Application number: 2019/93605	
What is the application for?:	Erection of 2 detached dwellings
Address of the site or building:	April Court, Roberttown, Liversedge, WF15 7RB
Postcode:

Type of comment: An objection

SITE PLAN 1:250

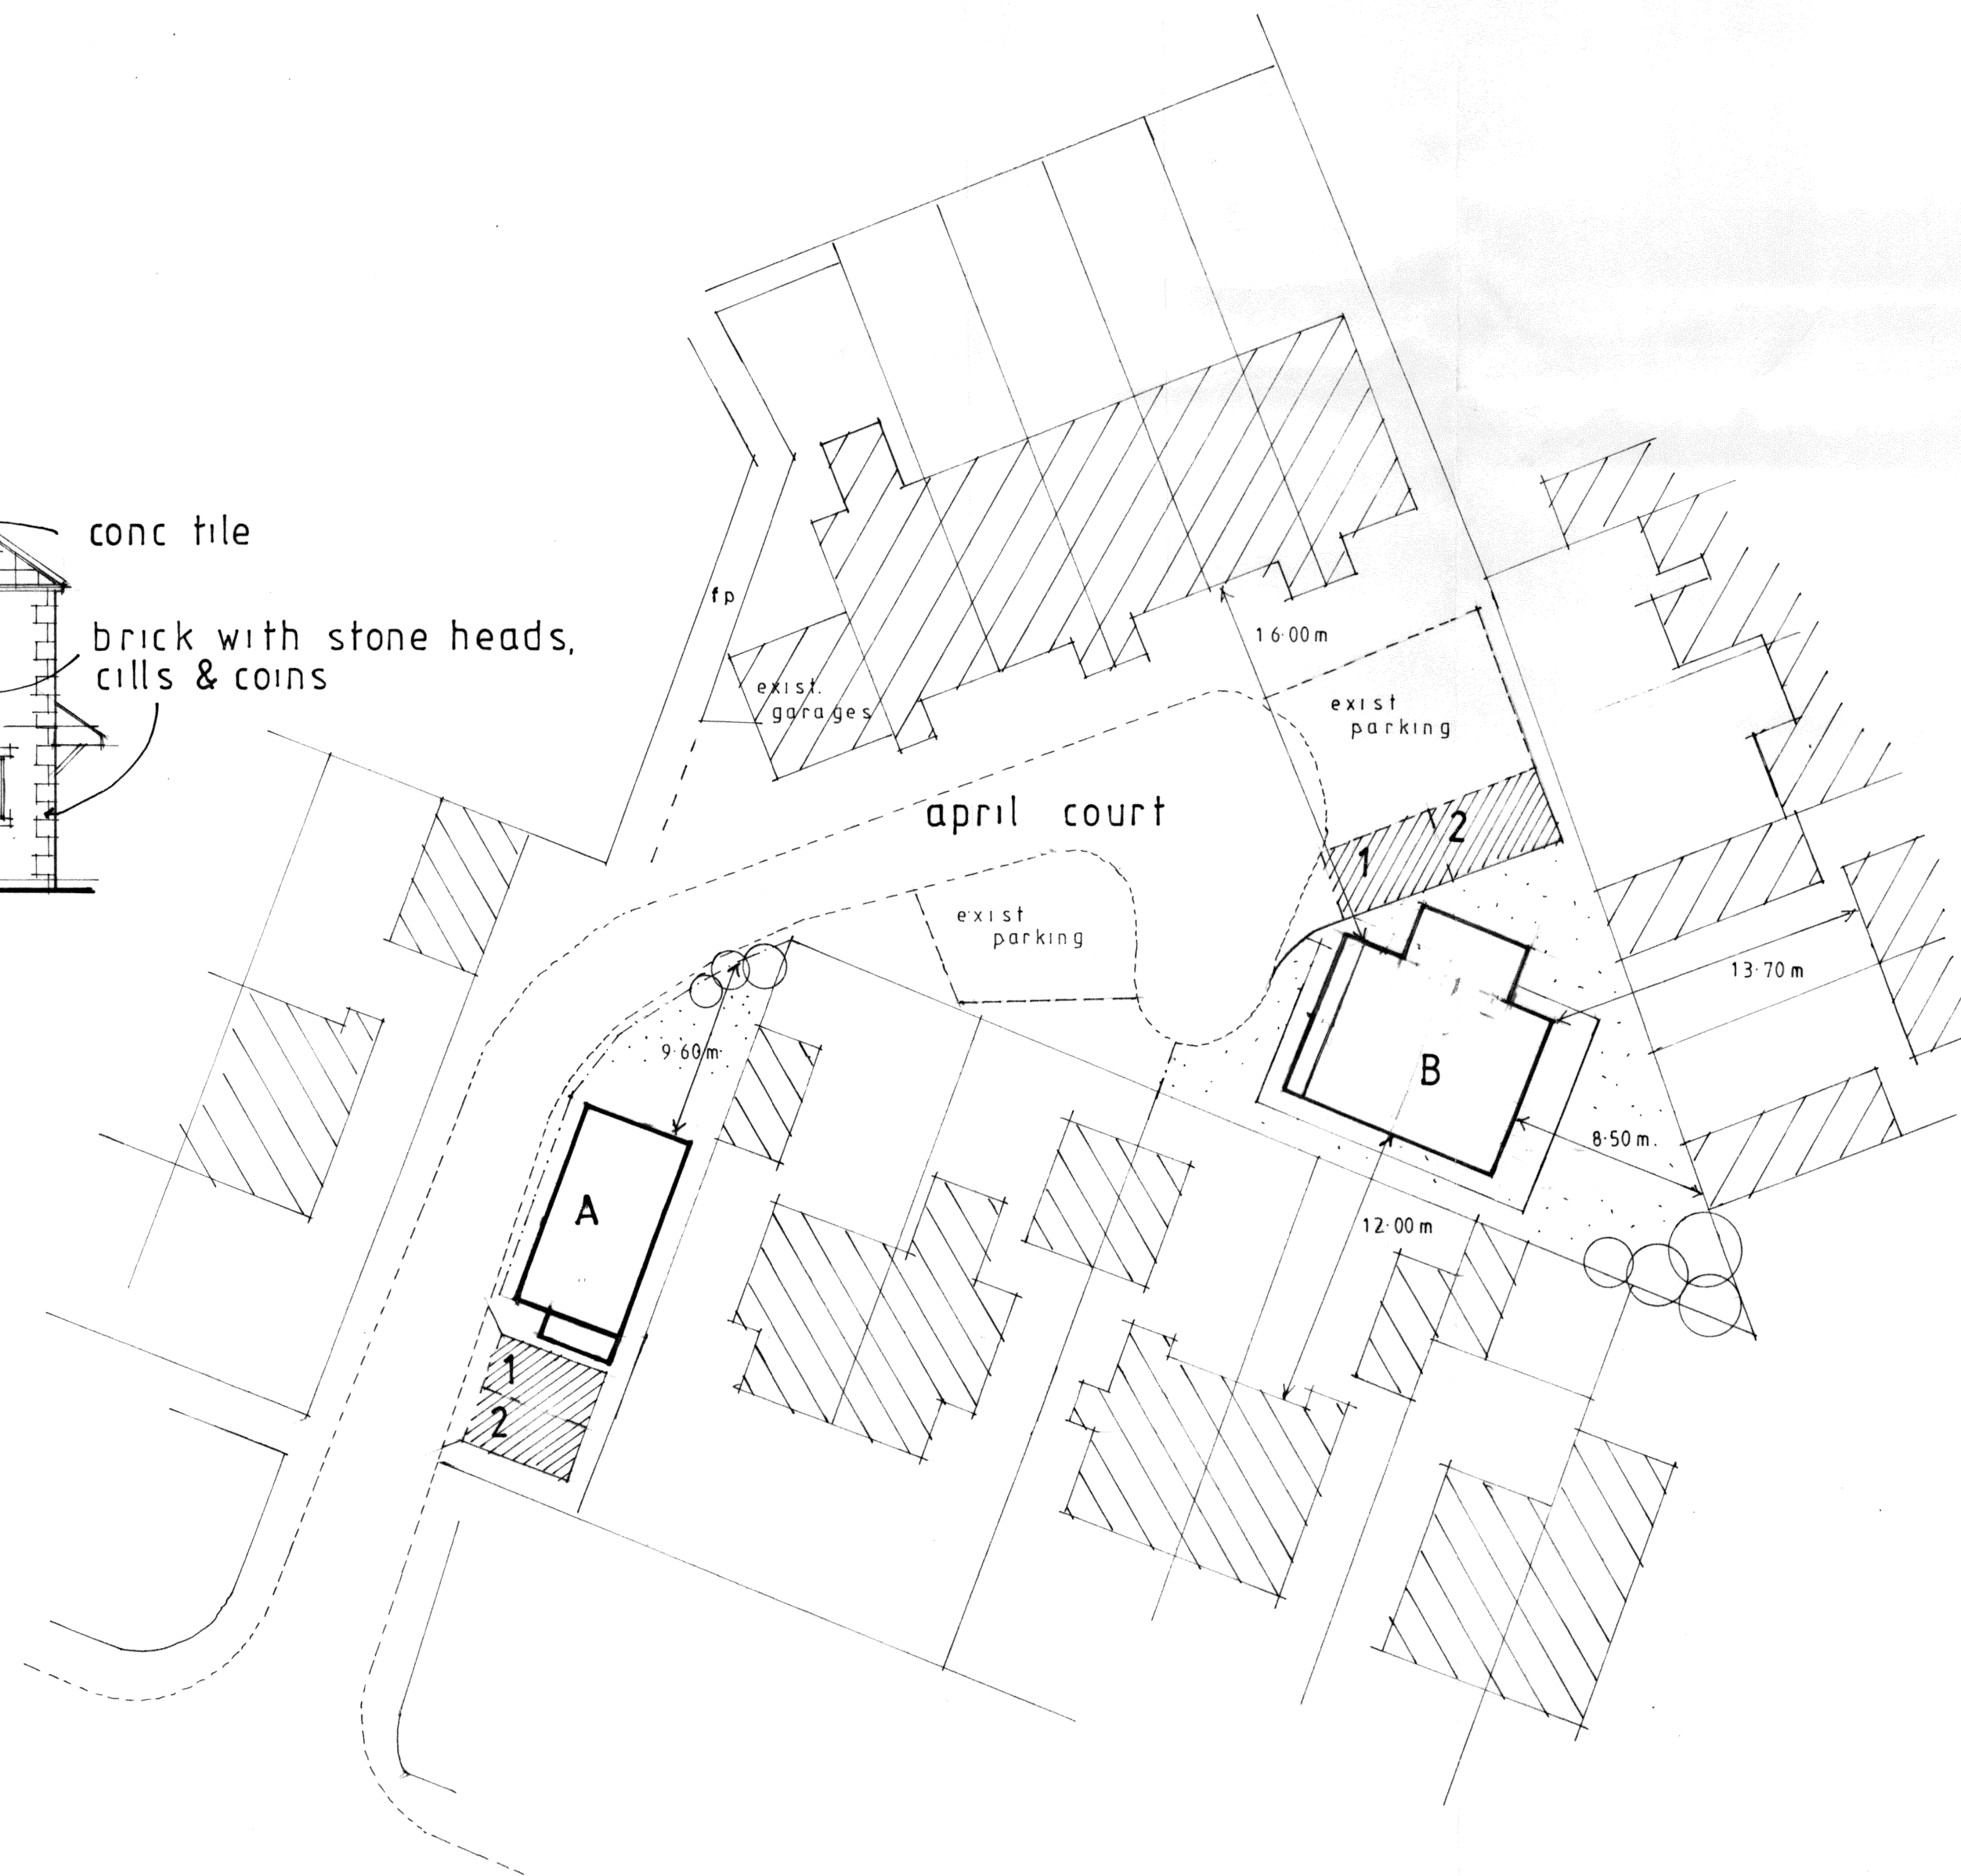
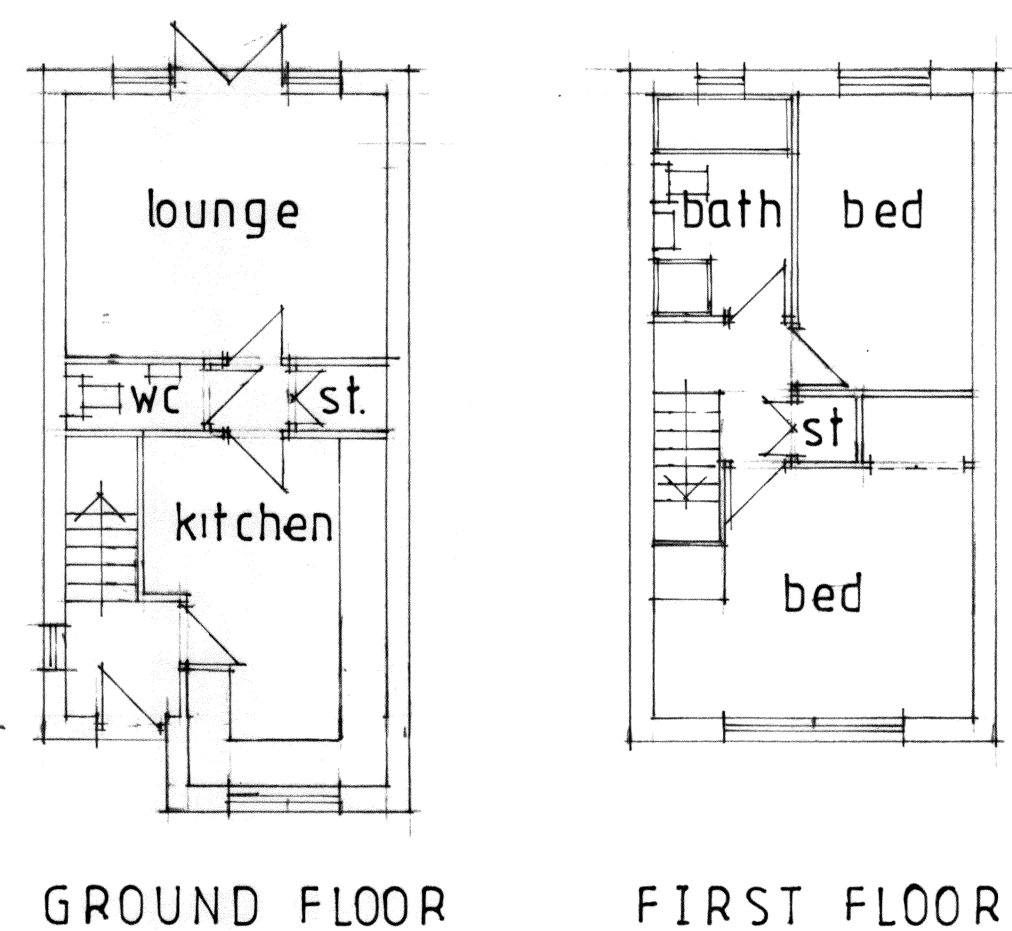
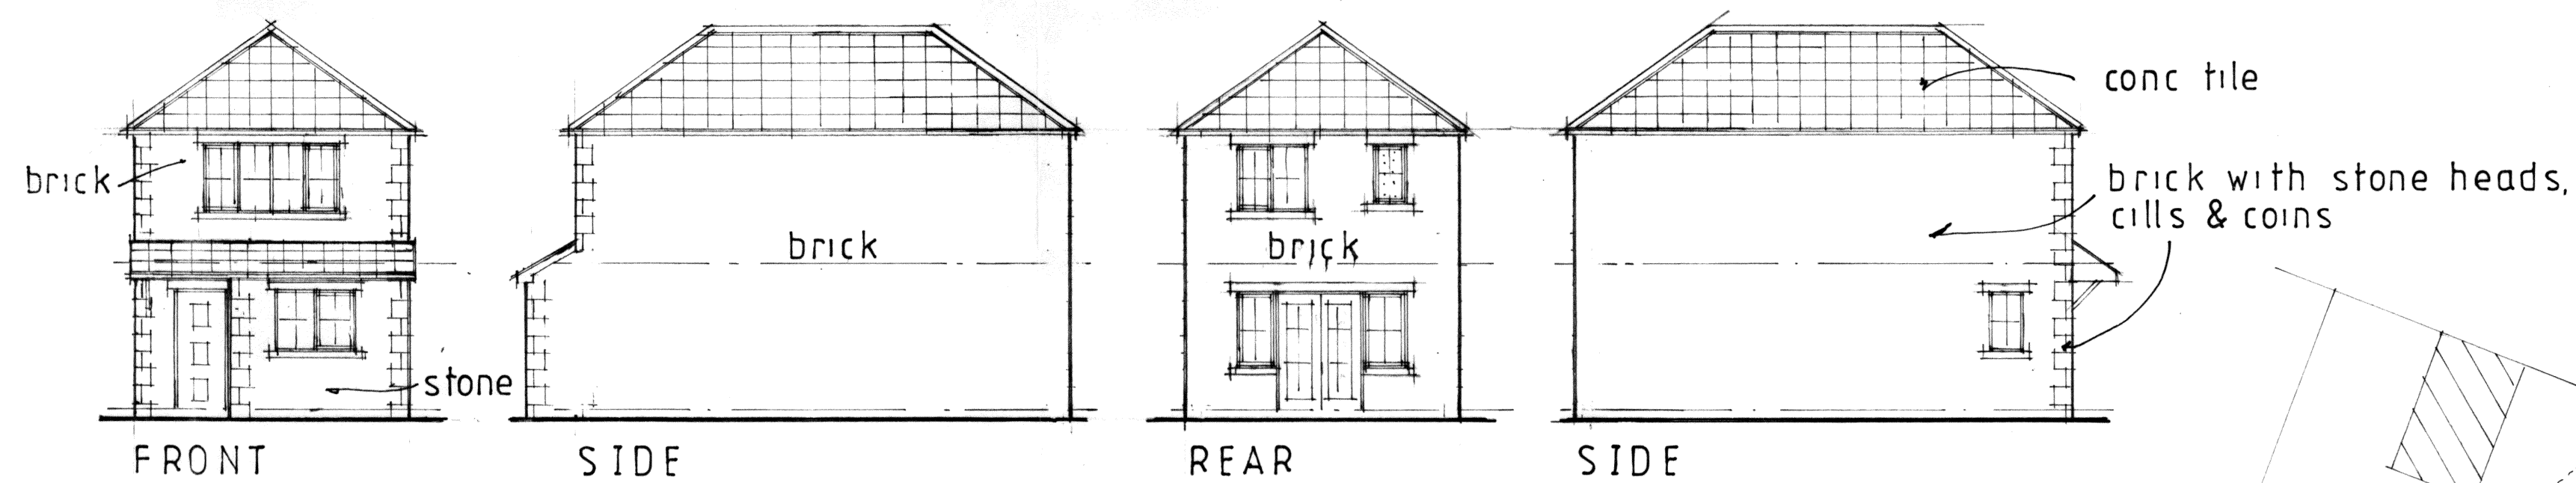
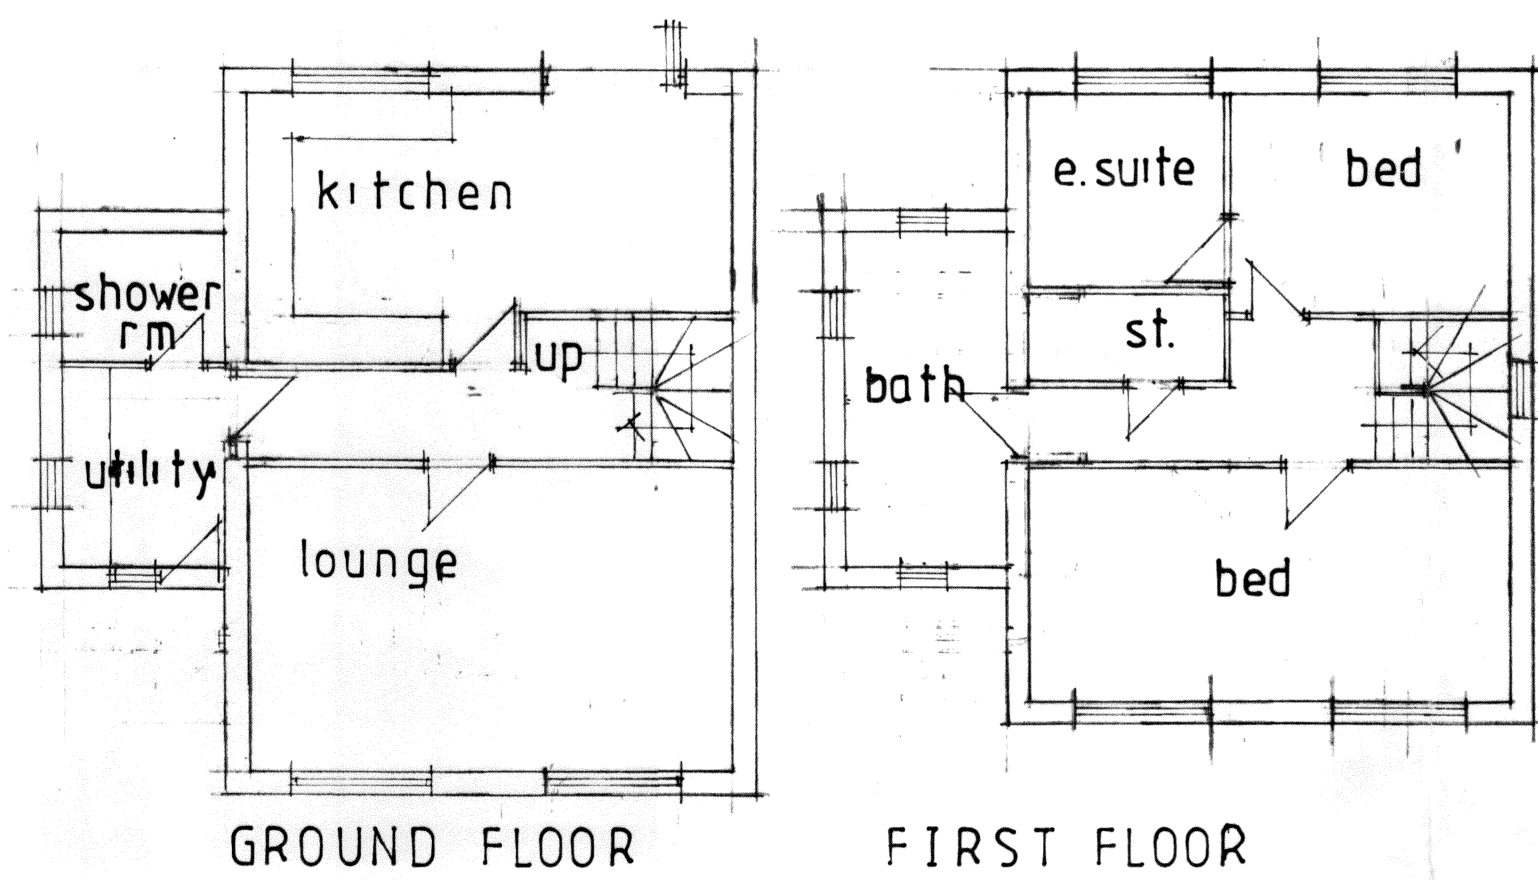
The plans for development (B) appear to lay claim to a proportion of this area.

On the plans for development (A) it has 2 parking bays, these are set at a 90 degrees to the access Rd, meaning that the vehicles would have to reverse in or out across the access Rd. Because the Rd is narrow this would impinge on the pathway, also causing obstruction/danger to any vehicle entering or exiting April Court.

The development would also create a larger blind spot for those rounding the bend within the Court and therefore increasing the danger of an accident.
